CIVIL DRAWINGS FOR MERIDIAN RANCH FIELD HOUSE IMPROVEMENT PLANS

PREPARED FOR MERIDIAN SERVICE METROPOLITAN DISTRICT

El Paso County
Major Commercial Site
Development Plan

CIVIL COVER SHEET

C3.0

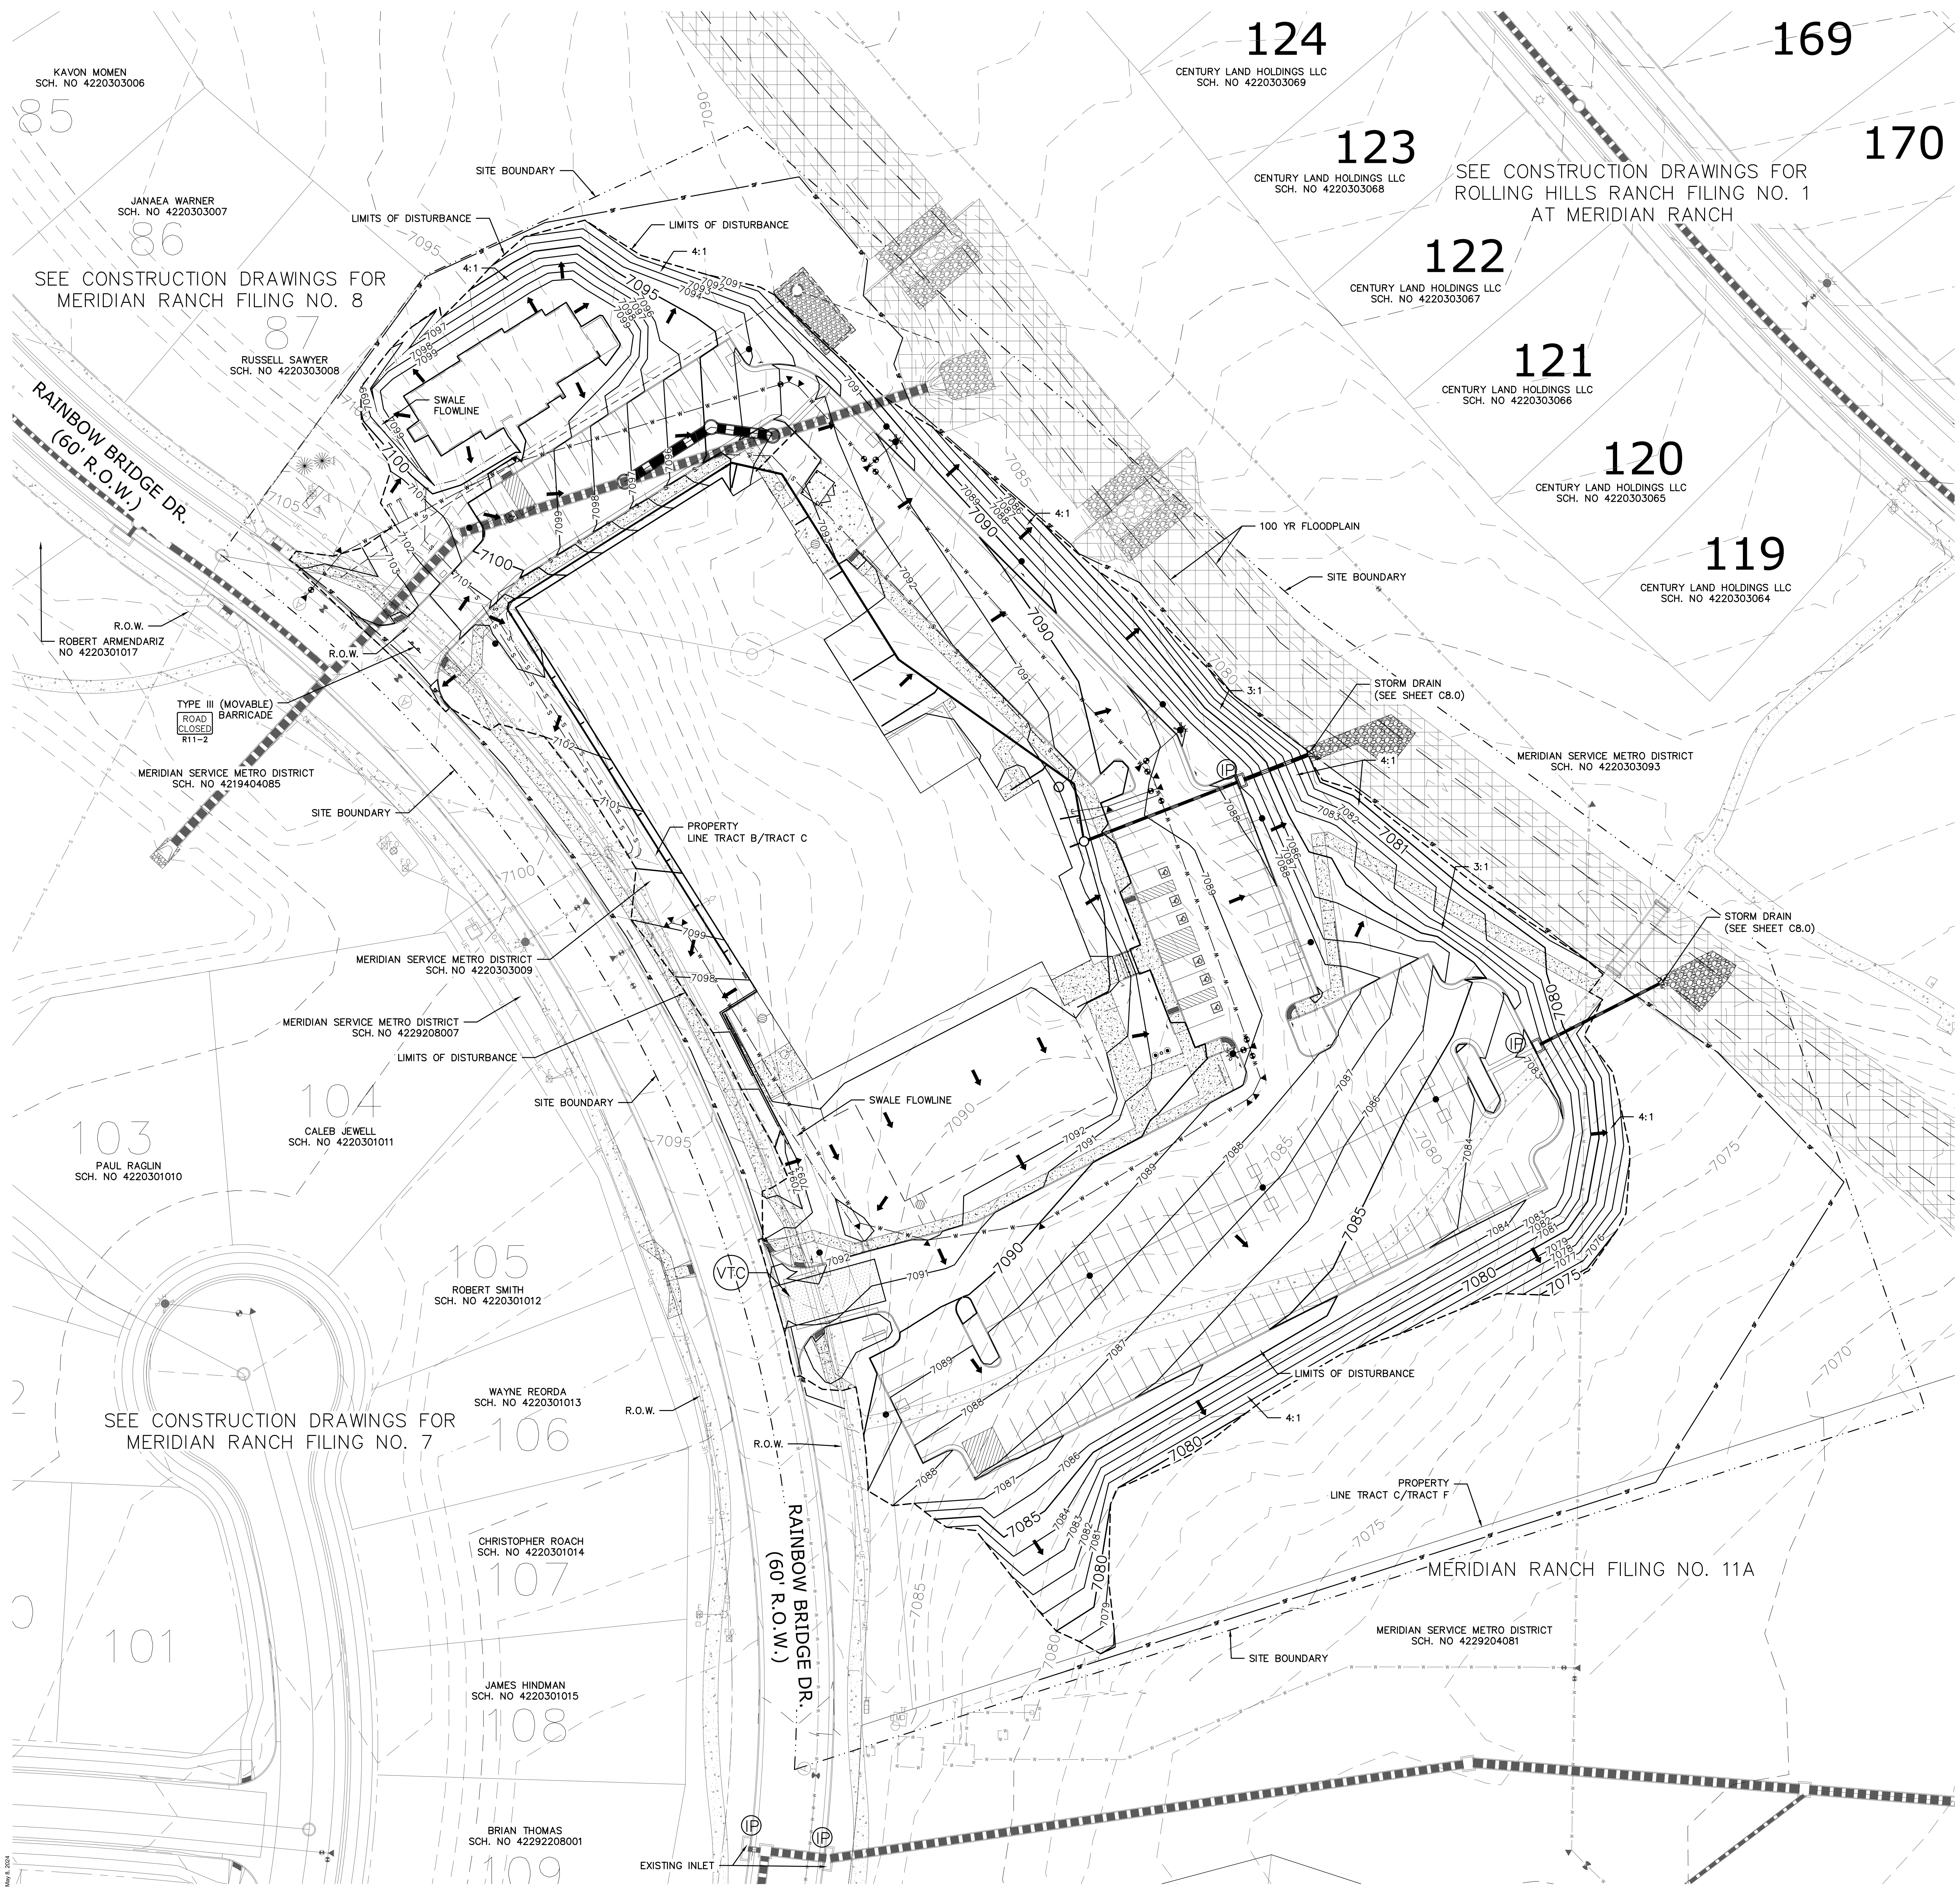
The SWMP references 1 acre of offsite disturbance associated with the project. Show that site and all relevant construction measures in the GEC Plans.
